***Planning Department
Transportation Development Services***

March 4, 2015

**Re: Rio Bravo Brewing Company, LLC
1912 Second St. NW
Traffic Circulation Layout**
Engineer's/Architect's Stamp dated 2/12/15 (H14-D105)

SITE PLAN

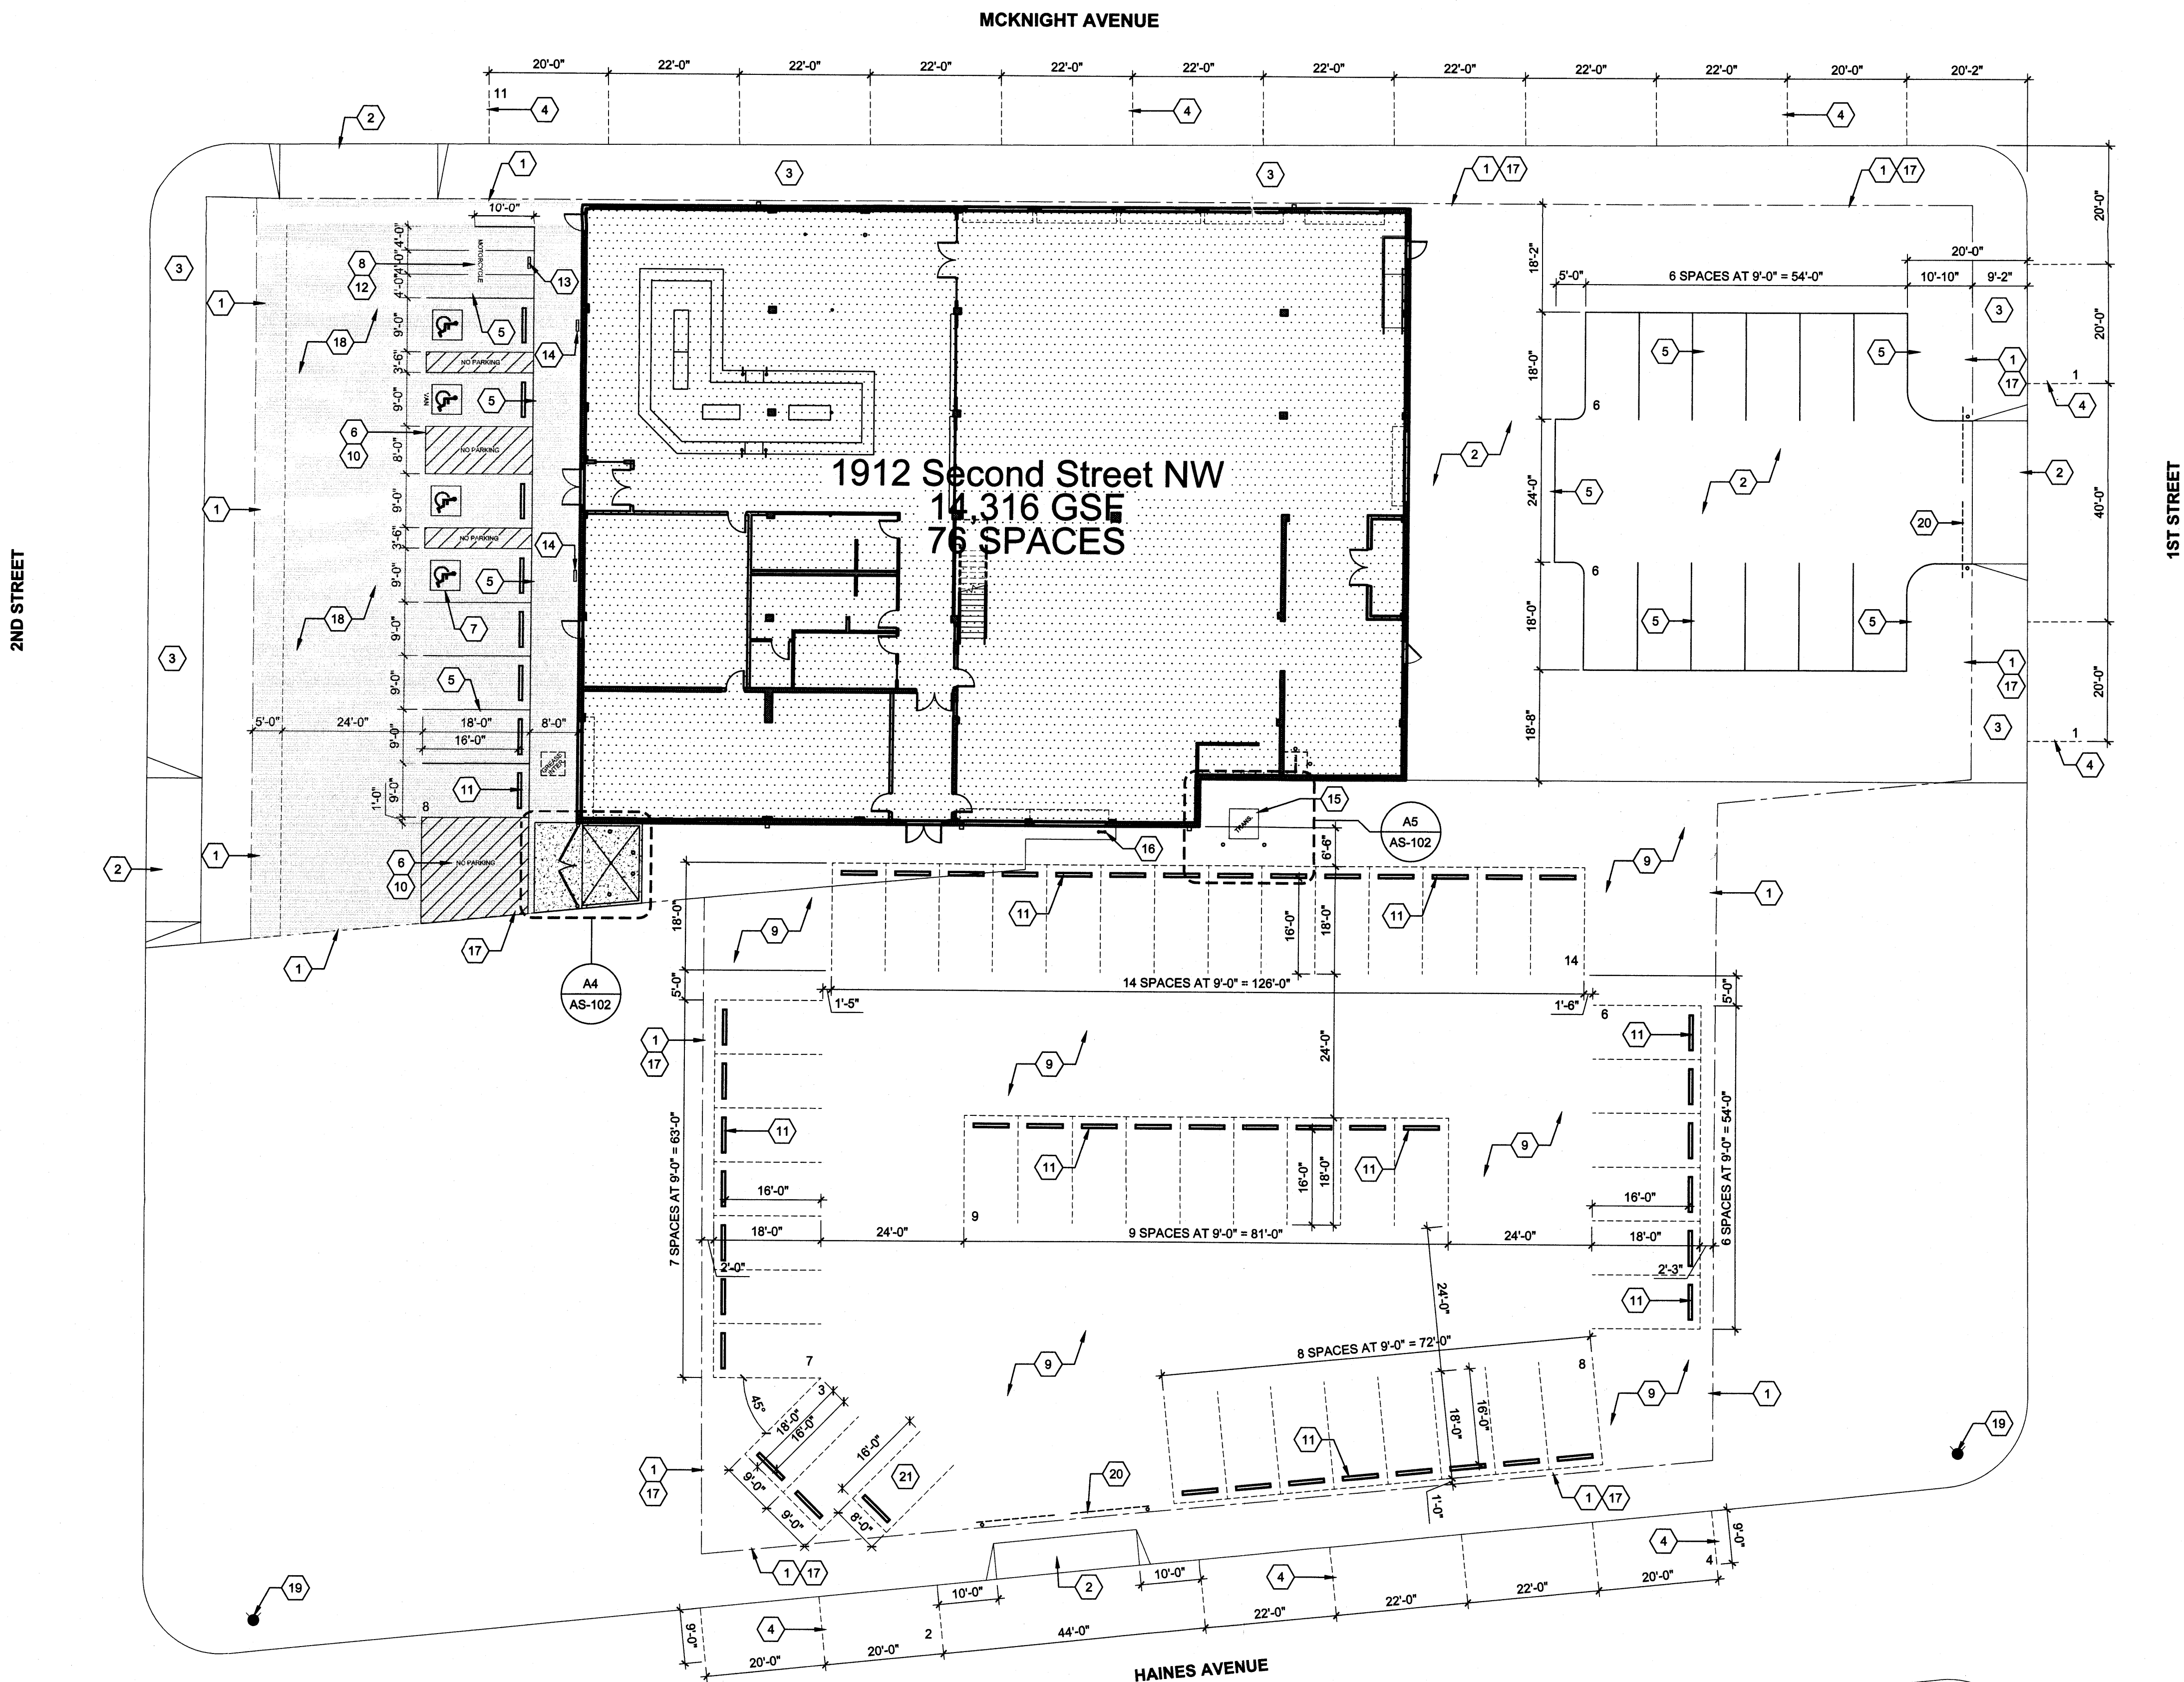
1. Please show a vicinity map showing the location of the development in relation to streets and well known landmarks.
2. Clarify the extents of the current phase of development. Please show existing surrounding buildings, property lines and easements.

3. Please label set-backs for building.
4. On the next submittal, please label drawing as "Traffic Circulation Layout" in lieu of "Site Plan".
5. A scale of 1"=20' is recommended for sites less than 5 acres.

6. Please identify all existing buildings, doors, structures, sidewalks, curbs, drive pads, walls, fences, gates and anything that influences the parking and circulation on the site.

7. Identify all existing access easements and rights of way with dimensions.
8. Identify the right of way width, medians, curb cuts, and street widths on 2nd St., McKnight Ave. Haines Ave. and 1st. St.

9. Clearly show existing sidewalk and handicap ramps within the Public R.O.W.
10. Please provide more detail on grades and slopes in the parking area and/ or the handicap accessible parking areas.

13. Show all drive aisle widths and radii.
14. Please detail all pedestrian walkways, including entrance to building and fencing that directs pedestrian traffic to building entrances.

15. List radii for all curbs shown; for passenger vehicles, the minimum end island radius is 15 feet. Landscape island radius for delivery trucks, fire trucks, etc. is 25 feet or larger

16. A five-foot keyway is required for dead-end parking aisles. Please detail keyway radii on drawing for parking lot south side of building Keynote #2.

17. Per the DPM, a 6 ft. wide ADA accessible pedestrian pathway is required from the public sidewalk to the building entrances. Please clearly show this pathway and provide details.

18. Per the DPM, a 6 ft. wide ADA accessible pedestrian pathway is required from the HC parking stall access aisles to the building entrances. Please provide greater detail of pathway and any elevation changes.

19. All sidewalks along streets should be placed at the property line, if possible.
20. Provide a min 6" or max 8" high concrete barrier curb or other acceptable barrier between landscaping and parking areas and/or drive aisles. Please show detail on drawing.

25. Work within the public right of way requires a work order with DRC approved plans.
26. On-Street parking is not required; please remove any indication of on-street parking from drawing.

27. Unused curb cuts must be replaced with sidewalk and curb & gutter. A build note must be provided referring to the appropriate City Standard.

**D6 POLE MOUNTED
H.C. PARKING SIGN**
1 1/2" = 1'-0"

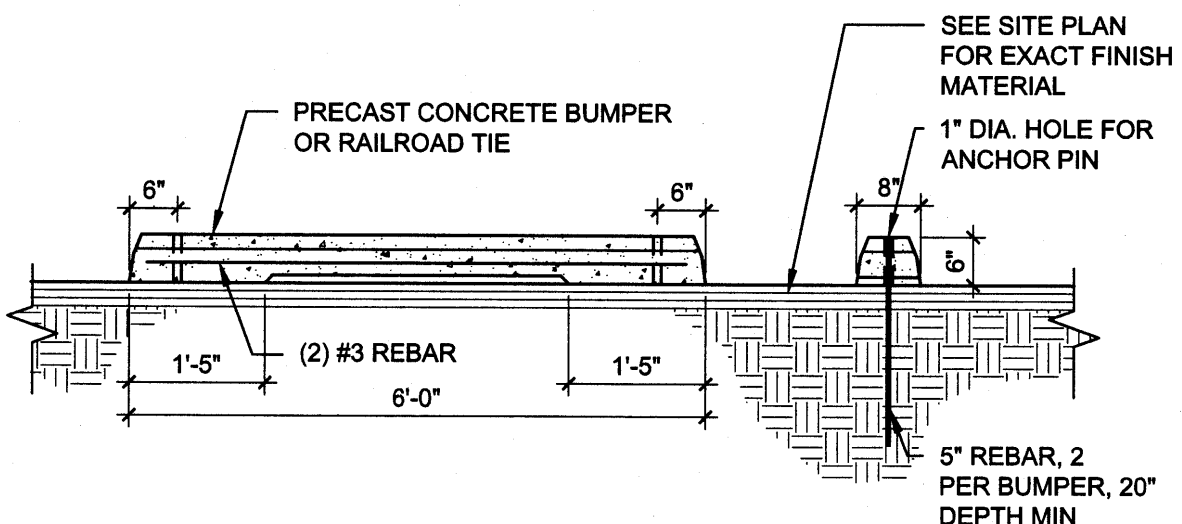
11. The ADA van accessible sign must have the required language per 66-7-352.4C NMSA 1978 **"Violators Are Subject to a Fine and/or Towing."** Please show detail on drawing.

A4 ENLARGED PLAN - TRASH ENCLOSURE
1 1/4" = 1'-0"

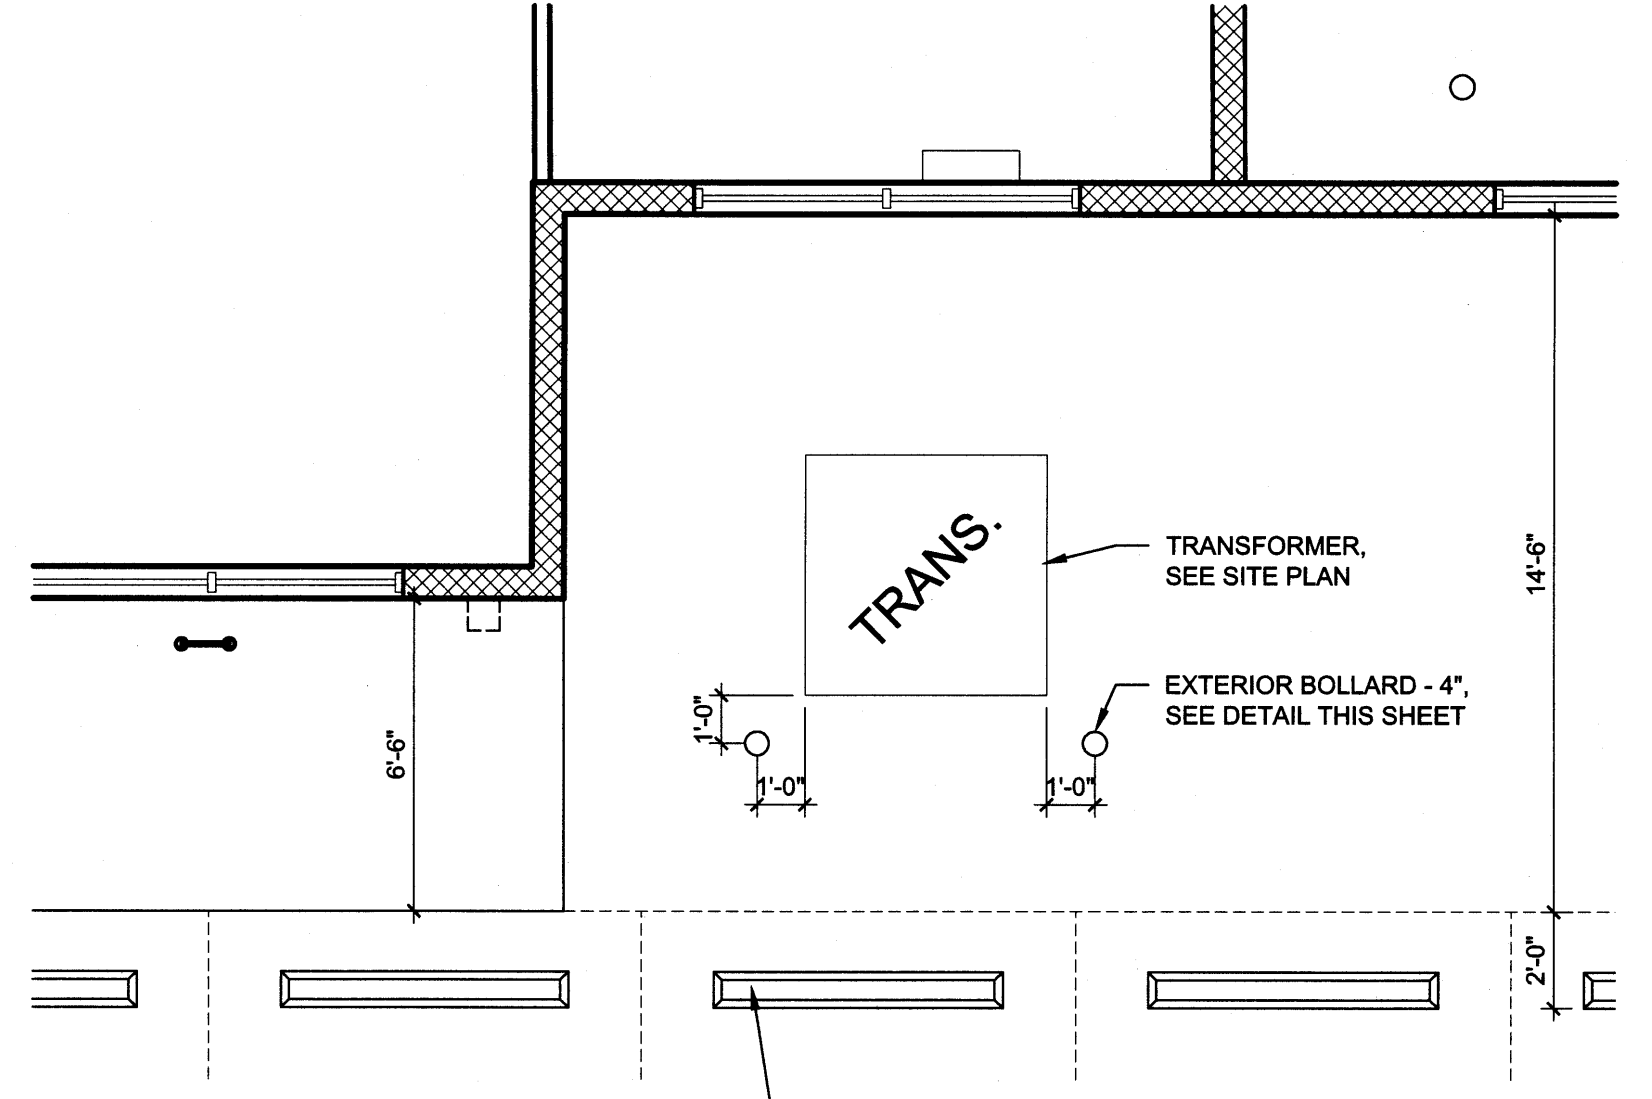
21. Design delivery vehicle route needs to be shown.
22. Service vehicle and/or refuse vehicle maneuvering must be contained on-site; provide a copy of refuse approval (if applicable). Please provide detail on A4, AS-102 callout.
